**From:** [Martina Mackin](#)  
**To:** [Nick Wright](#)  
**Subject:** RE: -21/00101/FUL  
**Date:** 24 February 2021 10:13:00

1. 1 The fenestration on the South and North elevations has been corrected.
2. 2 The Location and Site plans now show the proposed development.
3. 3 Both the rooflight and lantern on the single storey rear extension are visible from the sides.
4. 4 Parking for a minimum of 3 no. estate cars has been indicated, to scale, on the Location and Site plans.
5. 5 The East elevation has been added to the drawings to show that no part of the proposed extension will be visible from the front. The drawings have been revised to more clearly show the parapet screening the roof.

Drawing  
**Proposed Ground and  
 First Floors**

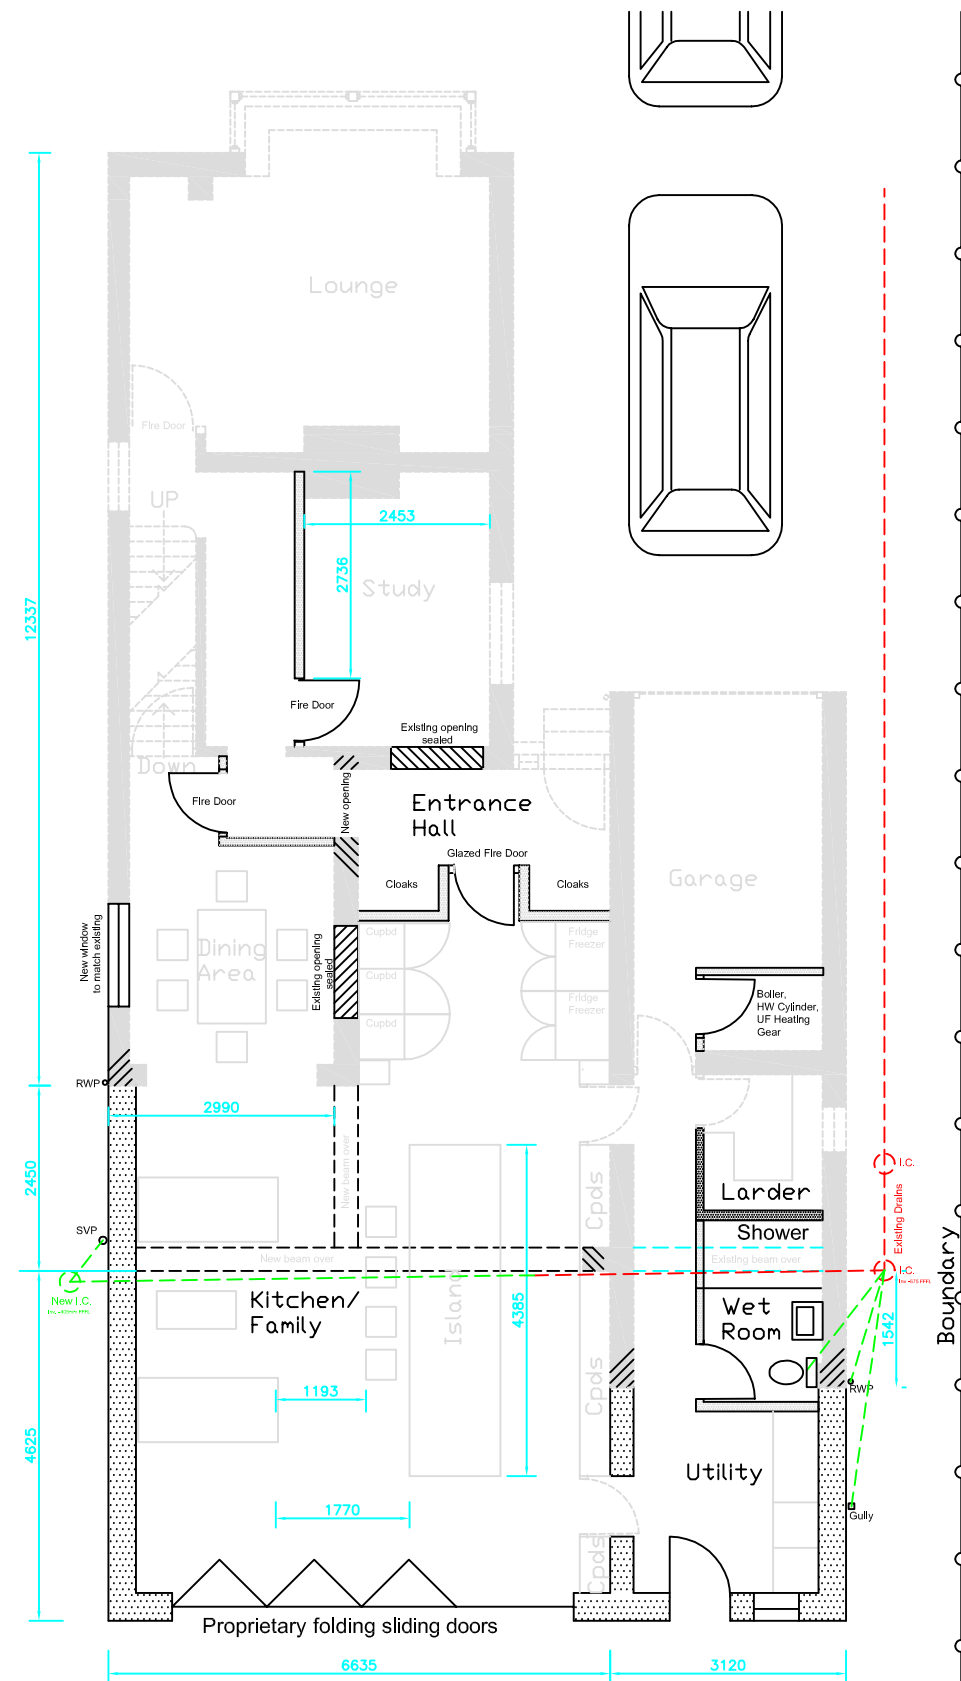
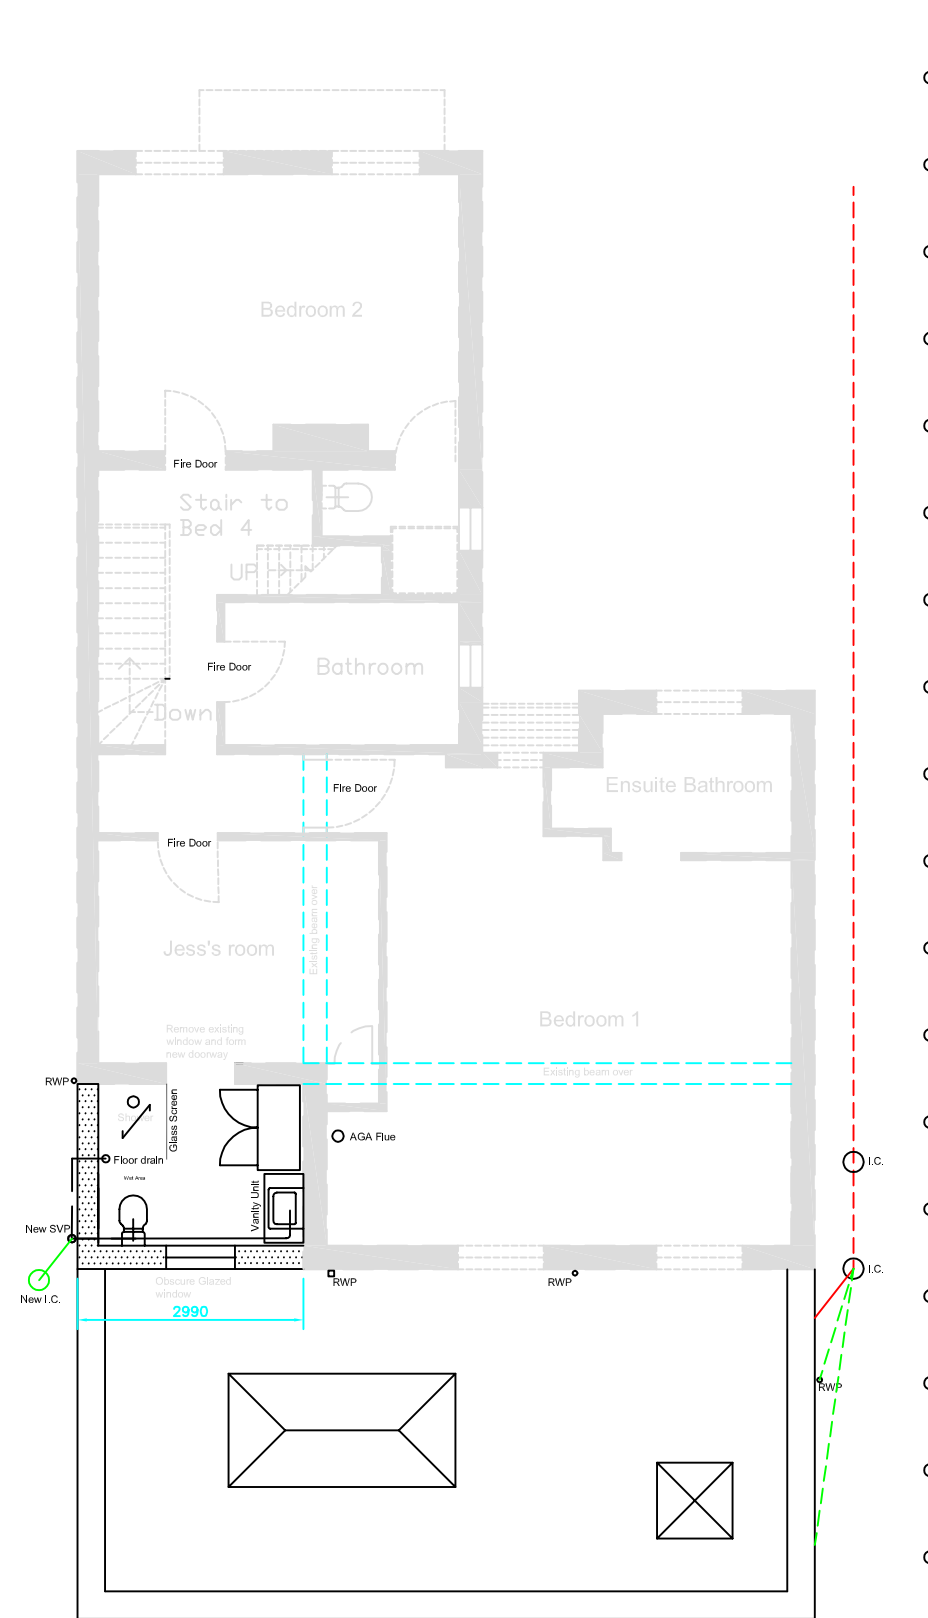
I apologise for coming back to you again, I gave the plans a final check before passing the application across for validation and I unfortunately noticed another inconsistency with the fenestration, the front elevation shows two windows which is shown as one larger window on the floor plan.

Drawing
 Existing Ground and
 First Floors

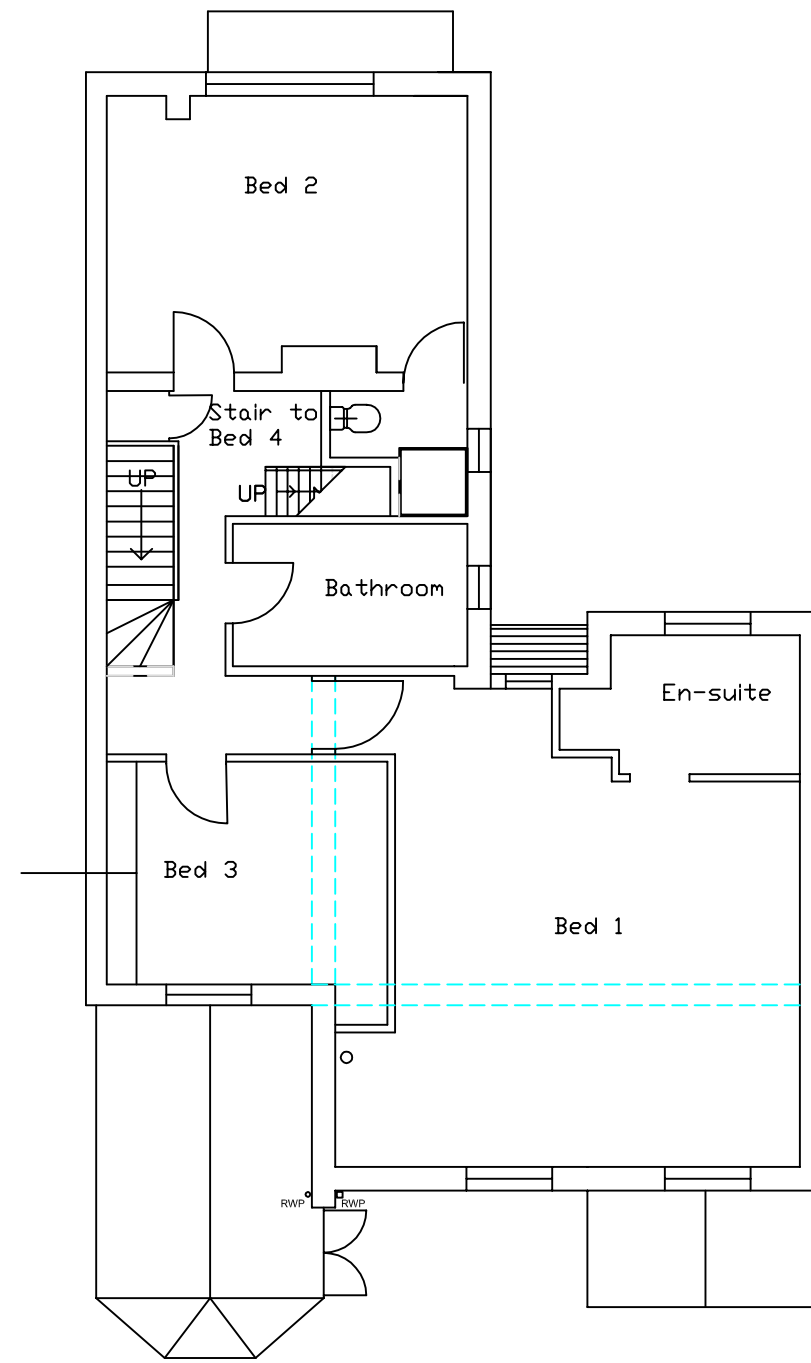
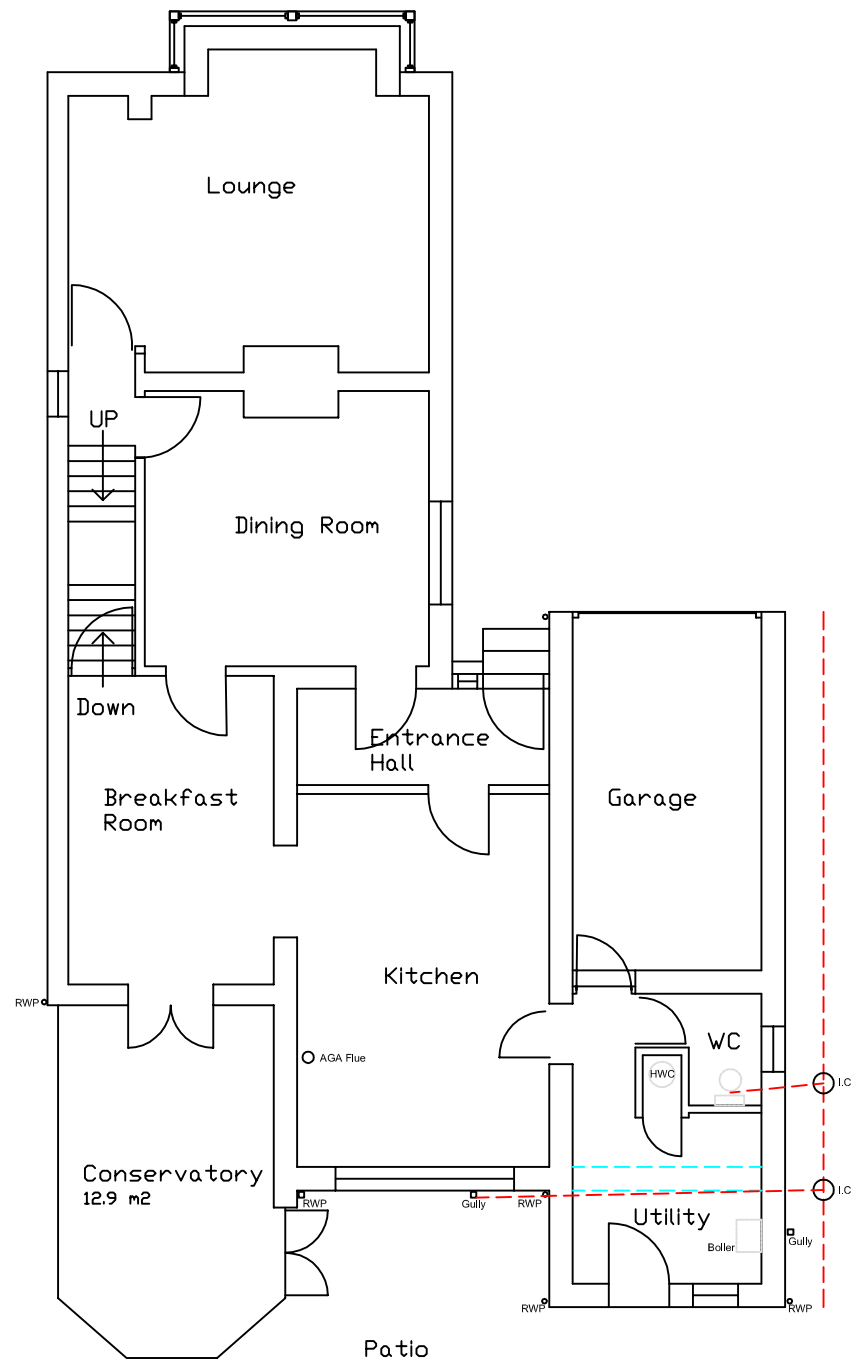
One more issue that still seems to be present is the window shown below, it does not appear to be shown on the existing or proposed floor plans but it is present on both elevational plans.
